PROJECT NAME: CSP SCAREBROOK  
EXISTING 68'-0" MONOPINE  
(OVERALL HEIGHT: 73'-0" A.G.L.)  
COLLOCATION COMMUNICATION SITE

SHEET TITLE:  
ELEVATION

SAVE DATE: 8/28/2018 9:03 AM  
SHEET NUMBER: Z3

# Markup Summary

C.O.R. =	CENTER OF RADIATION
A.L. =	ATTACHMENT LEVEL
B.T. =	BOTTOM TIP LEVEL
T.T. =	TOP TIP LEVEL
A.G.L. =	ABOVE GRADE LEVEL
B.O.B.P. =	BOTTOM OF BASE PLATE

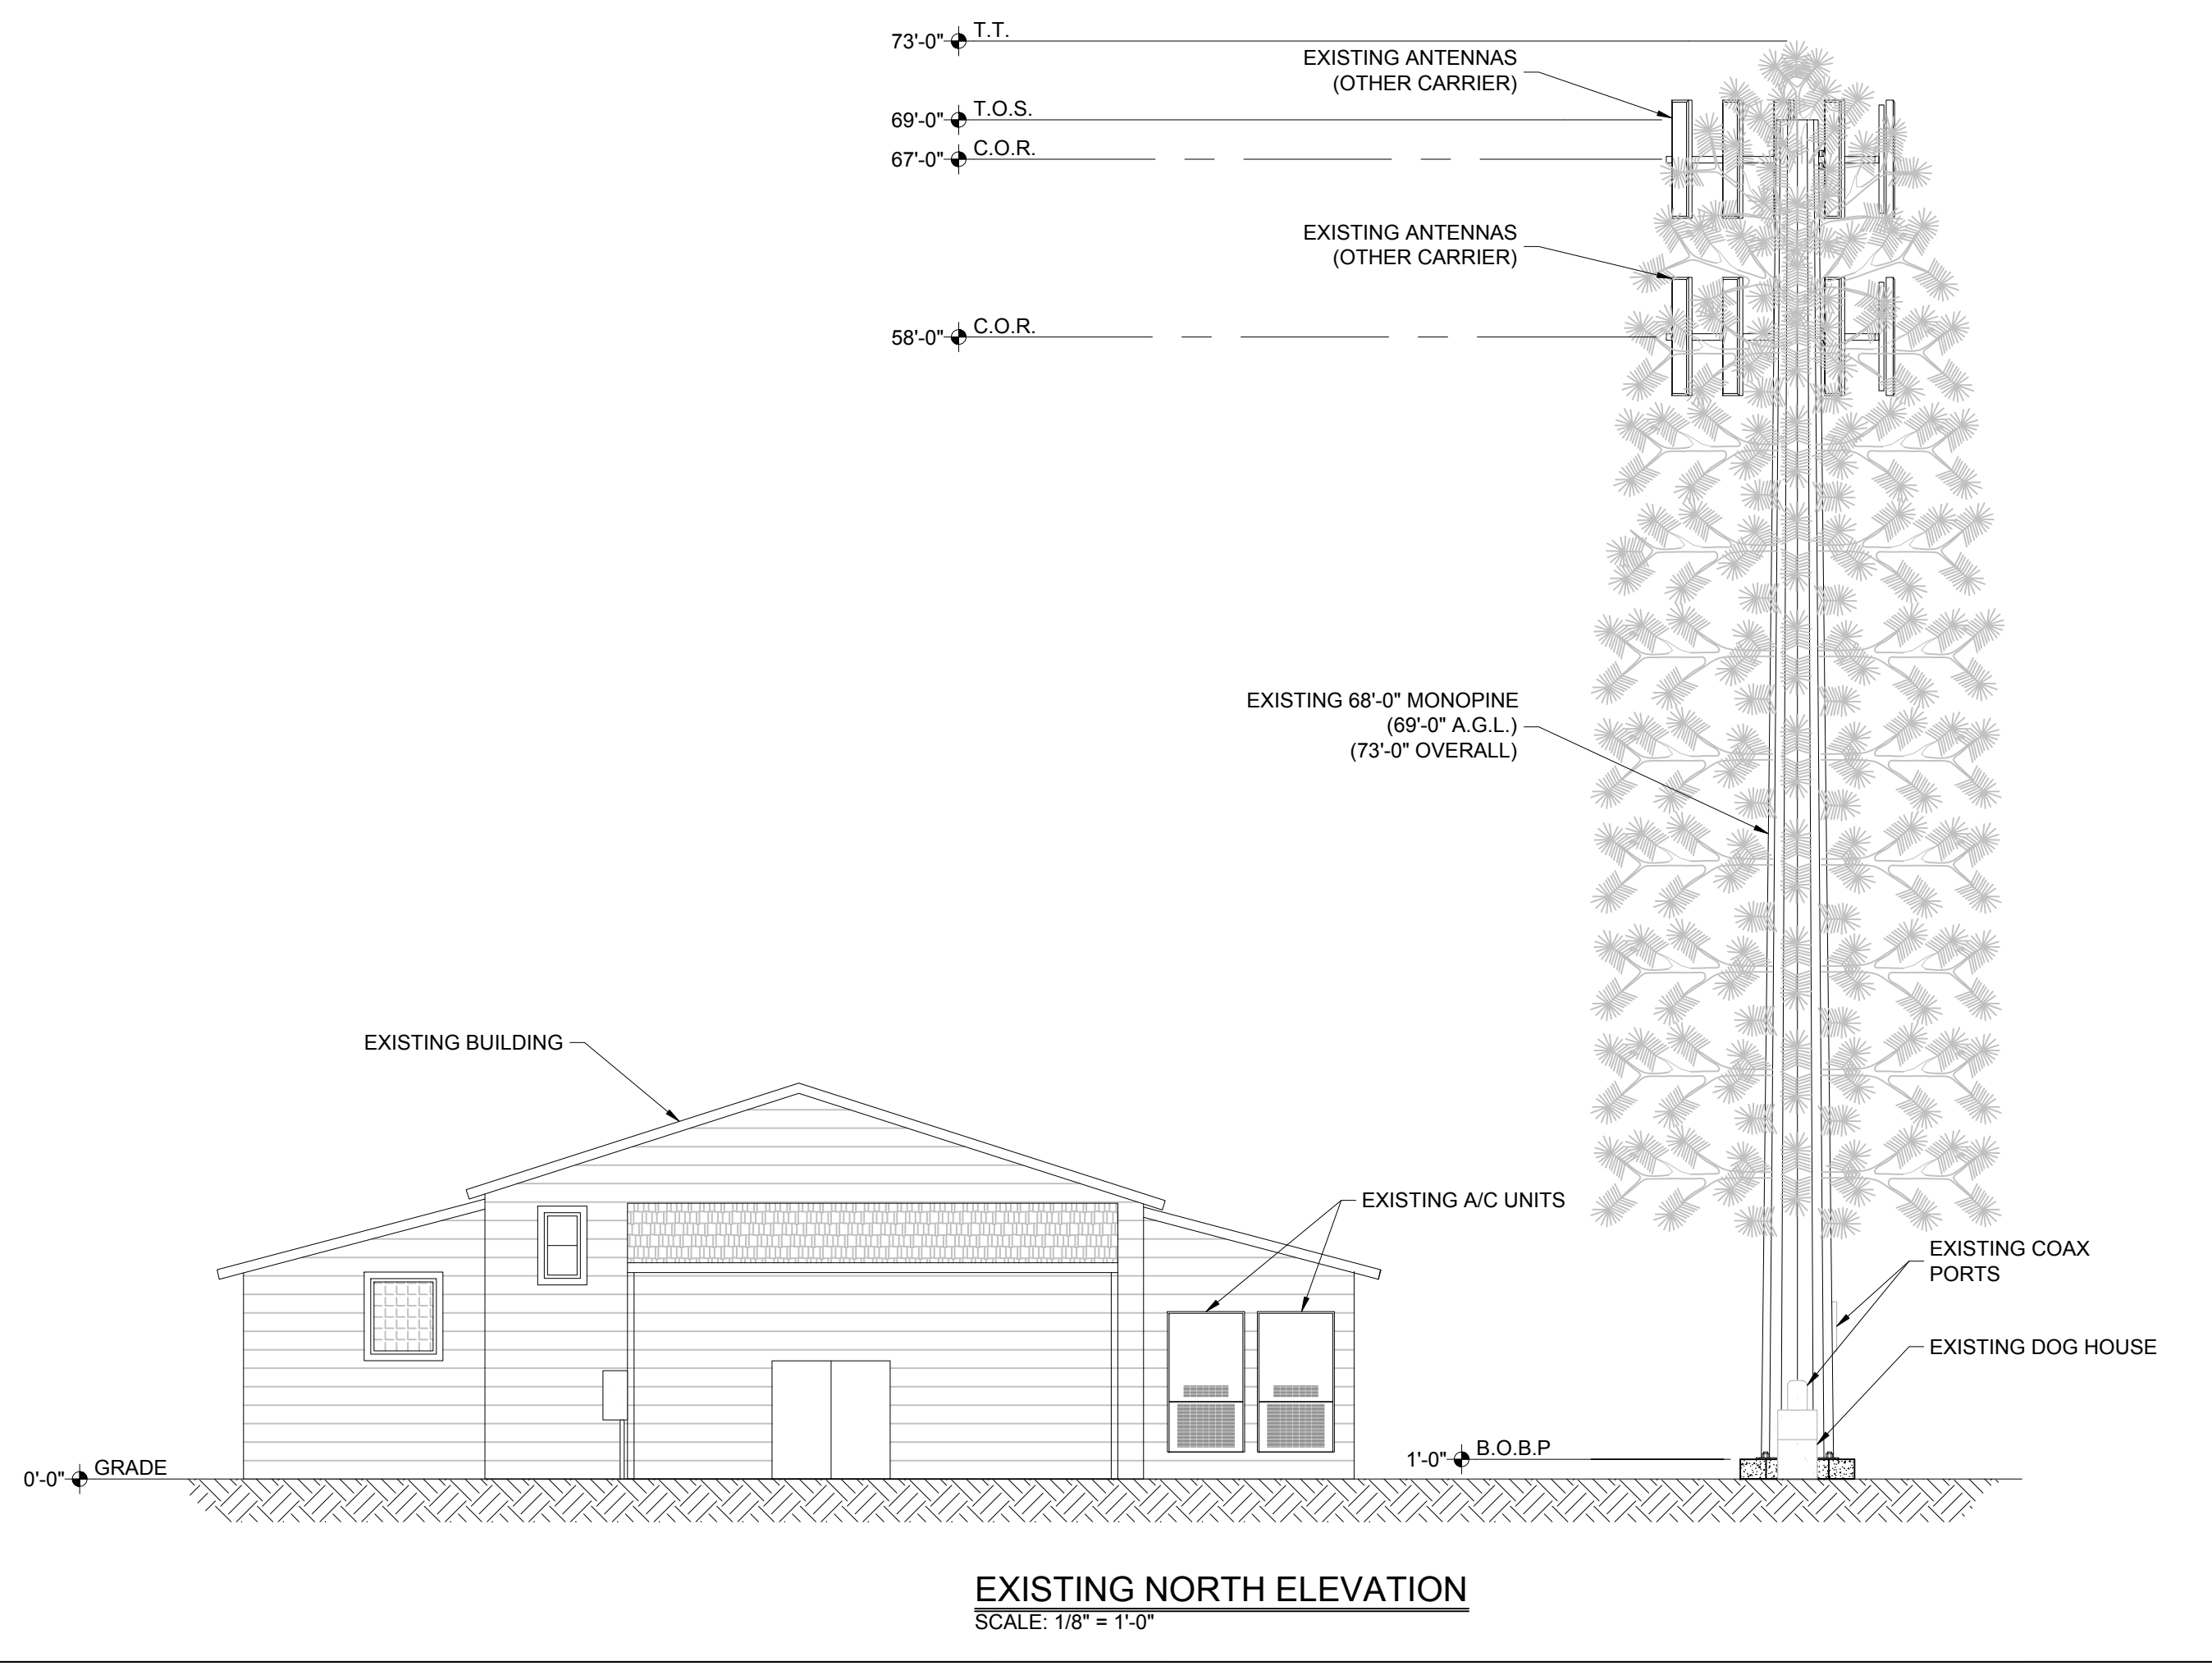
Is this stealth or non-stealth as stated on record in the resolutions of va122.  
Are the branches existing?  
Show the top of the antennae at 70' not the middle at 69'.
